SUBJECT: P/140/16/OUT - Outline application for access only - mixed use development comprising of up to 400 dwellings, a care home with up to 70 beds, a Local Centre comprising up to 2000sqm of A1/A2/A3/D1/sui generis floorspace, provision of land for a 1FE primary school (with sufficient space to ensure that it is expandable to 2FE), provision of land for a scout hut, safeguarding of land to help link the site to the Pagham Harbour Cycle Route & other community uses including public open space & allotments with some matters reserved. This application is a departure from the Development plan.

Land South of Summer Lane & West of, Pagham Road, Pagham, West Sussex

RECOMMENDATION:

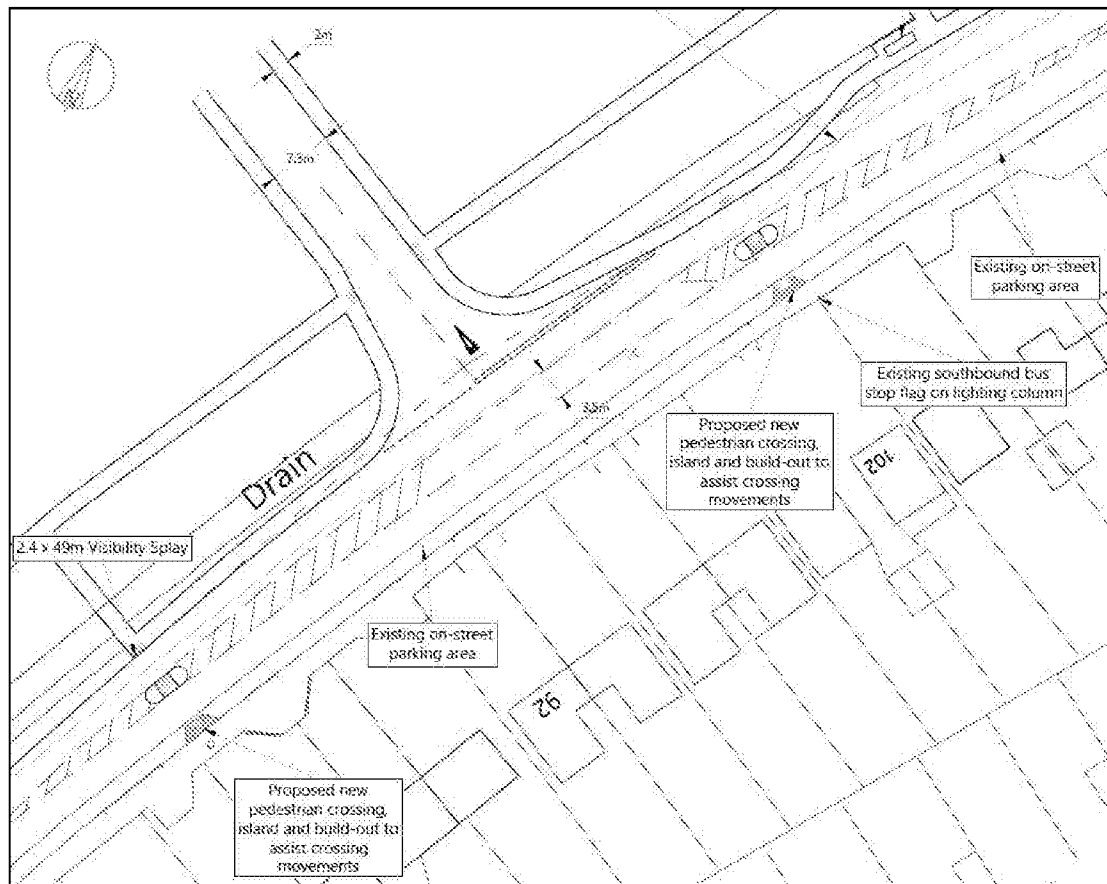
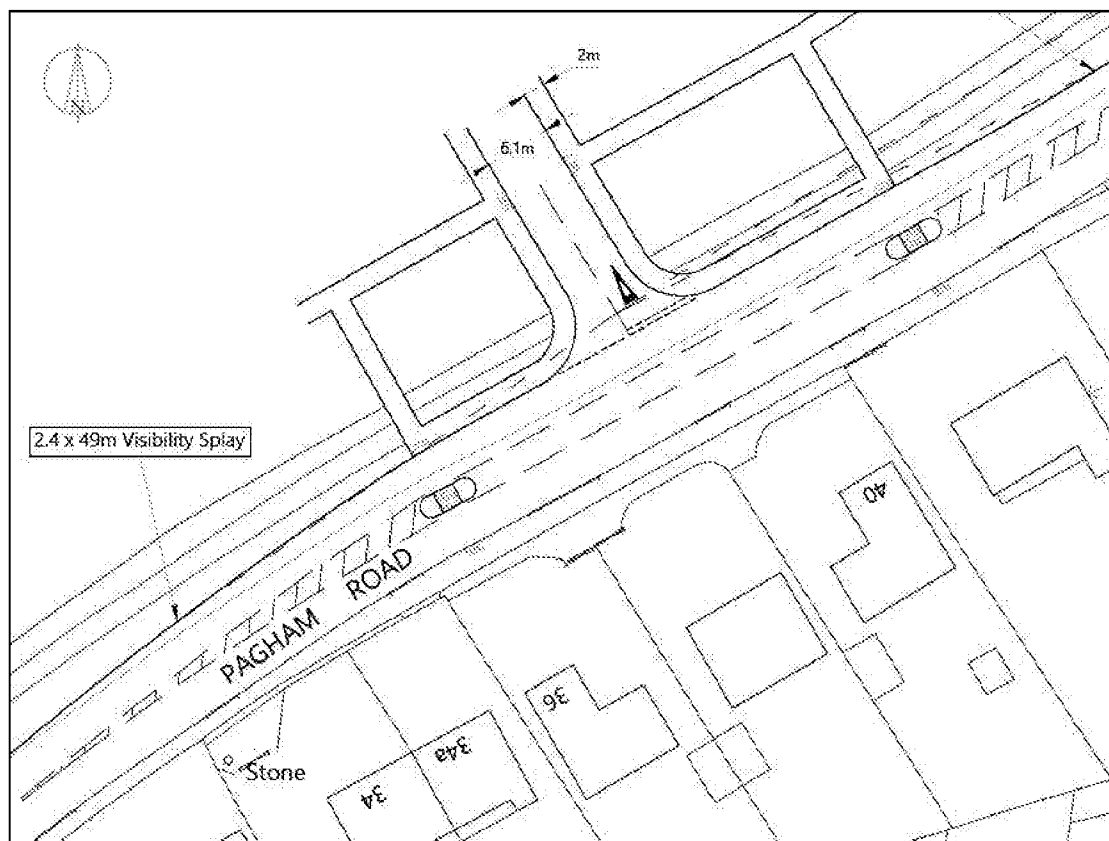
5. Various matters were raised relating to the principle of the access arrangements as well as the detailed design. The LHA still consider that the provision of right turning lanes conflict with the design principles within Manual for Streets 2. However, the LHA also recognise that local carriageway widening is necessary in order to accommodate pedestrian refuges. The right turning lanes are not provided for capacity or safety reasons.
6. The LHA have therefore viewed the access designs on the basis of providing carriageway widening for the pedestrian refuges rather than for the specific purpose of accommodating formal Design Manual for Roads and Bridges compliant right turning lanes.

7. In terms of more detailed matters, the pedestrian refuges have been widened to 2 metres. Kerb to kerb carriageway widths between the refuges and carriageway edge exceed the required WSCC minimum widths of 3.5 metres. Where necessary at the northern access, build outs are included to ensure that pedestrians do not cross between parked cars.

8. A further pedestrian crossing point is provided on the southern side of the access to the Parish Council's car park along with a build out on the opposite side of the carriageway. This lies immediately adjacent to a residential access. Although the tracking drawings (which is based on OS data rather than a topographical survey) indicates that a standard vehicle could turn into the residential access, in practice given the close vicinity of the build out to the access, it would be more desirable to extend the footway on the northern side of the carriageway and relocate the crossing further north (for example to the immediate east of the Parish Council car park access).

- a. 2.1.1 – The bus stop lay-by is understood to be the same dimensions as that already present. Providing it is demonstrated that a bus can stop entirely within this, the dimensions are accepted.

- b. 2.2.1 – Requires the provision of a central island to prevent overtaking within the hatched area at the bus stop. A traffic island has been provided. It has previously been advised that the LHA have experienced issues with vehicles overtaking on the wrong side of traffic islands in order to pass a stopped bus. Having reviewed this, it is suggested that the traffic island is upgraded to a pedestrian refuge (this will then fulfil problem 2.3.1), and the matter of the vehicles overtaking buses considered as part of any Stage 3 Safety Audit once the works are in place. If issues do occur, a solution would be to relocate the bus stop rather than remove a pedestrian crossing off a desire line.

Figure 5.1 – Proposed mitigation at the Rose Green Road junction with Grosvenor Gardens

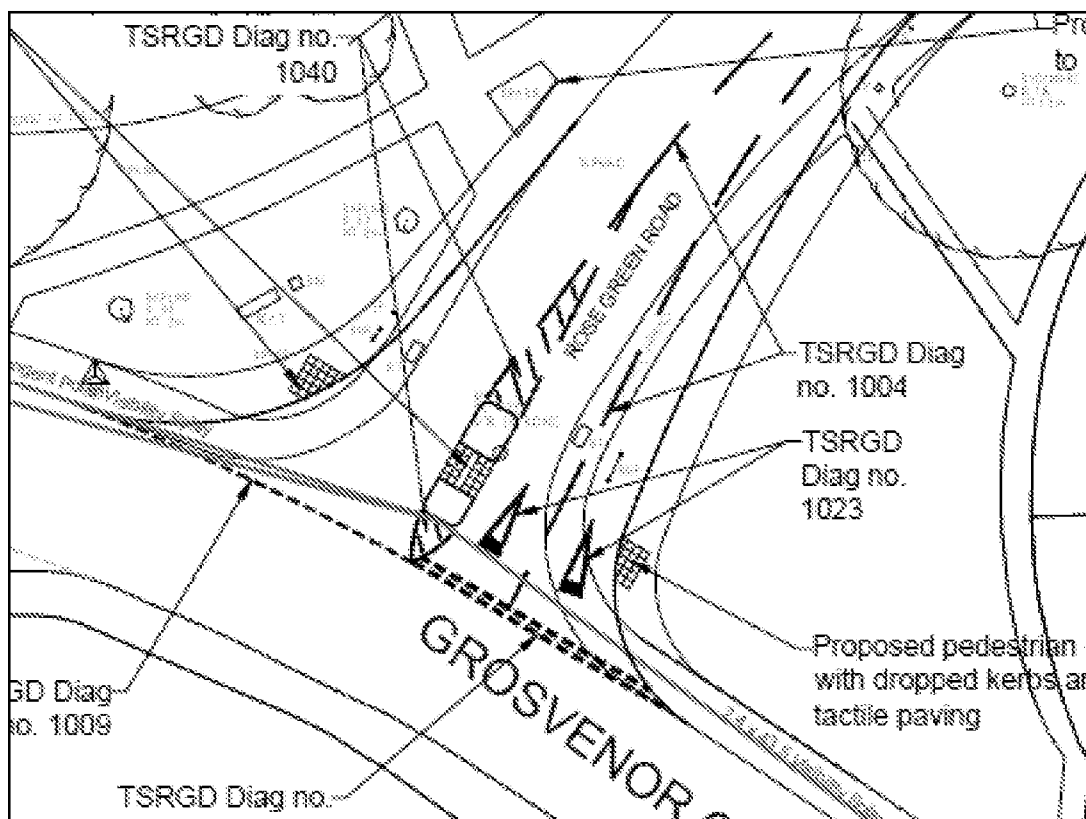
12. The only other matter that warrants further comment at this stage is the LinSig model used for the Gossamer Lane/Nyetimber Lane/Grosvenor Gardens junction. This still doesn't appear to include the pedestrian phases that are present on all arms. Notwithstanding this, the additional queues and delays resulting from the south of Summer Lane development alone compared with the without development scenario would not be considered severe.
